## SOUTH HOLLAND DISTRICT COUNCIL

**Purpose:** To consider Planning Application H11-0056-26

**Description:** Change of use from former gift & interiors shop to ground floor and hair & beauty salon on first floor to solicitors office to include alterations and insertion of rooflights

**Location:** 4 High Street Long Sutton Spalding

FRONT NORTH ELEVATION

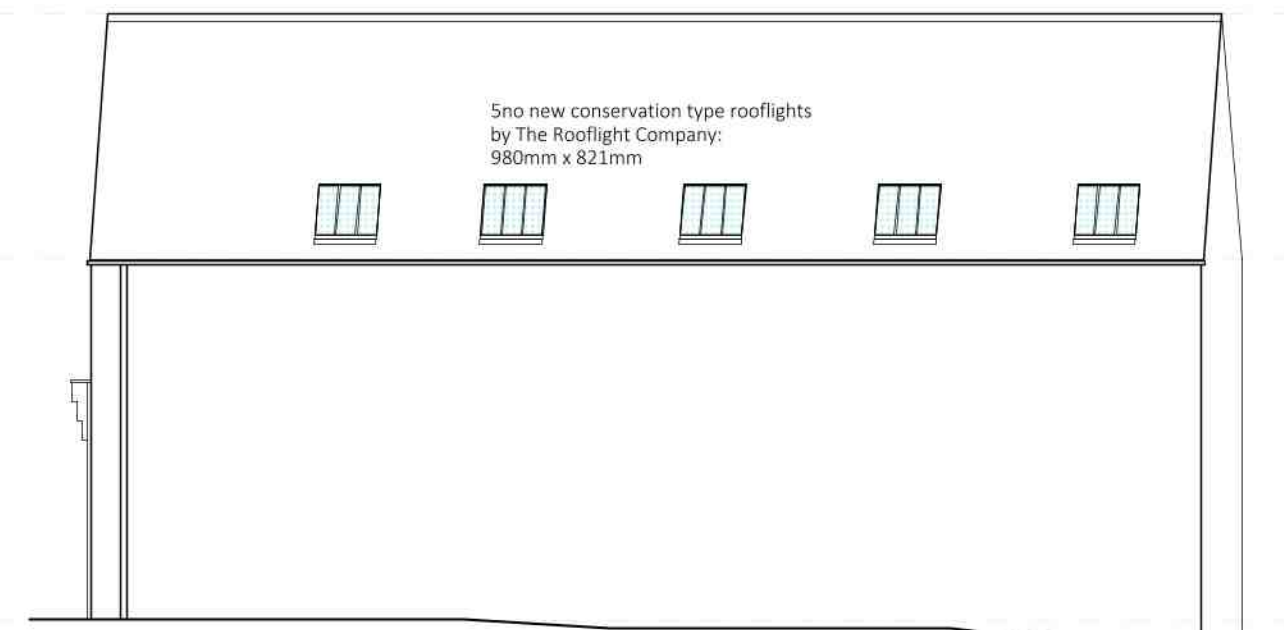
I write to confirm that I have no objections to this proposal. However, this is subject to several provisos and the possible need for further information prior to determination. I am satisfied with the basic principle of the proposal, and have no concerns with any aspect of the proposed scheme other than the proposed infilling of the inset coach door to the east side of the principal elevation.

6.8 I would therefore recommend that with reference to the proposed infill of the doors, detail should be provided showing that, in order to better replicate the appearance of the window situated immediately to its east, a matching chamfered brick cill will be used. Moreover, to ensure that the readability of the existing opening is retained, the brickwork and window should be inset and not flush with the existing wall. Should the application be approved, then I would recommend that a condition be applied requiring the detail of the proposed new window be submitted, and another requiring the frames to be painted black to match the existing fenestration on site.

6.9 Lastly, conditions should be applied ensuring that the brickwork matches the existing in terms of brick size and bond, and that the final brickwork on the frontage elevation be painted to match the existing finish on the facade, and to avoid any new brickwork appearing out of keeping with the remainder of the property. As a note, I would also recommend that for the avoidance of doubt, drawing no. 25037/PL04 should be amended to remove any references to 'timber panels' when the HIA seems to suggest that those panels would be windows. This vague wording could suggest a fully timber panel without glazing, in contrast with the HIA. Suffice to say, a solid timber panel situated on the front elevation would not be seen as acceptable.

4. Notwithstanding the text shown in drawing ref. 25037/PL04A, no external timber screen shall be installed within the principal elevation of the building.

6. All new window frames, and glazing bars shall be of timber construction, painted black and thereafter so maintained.
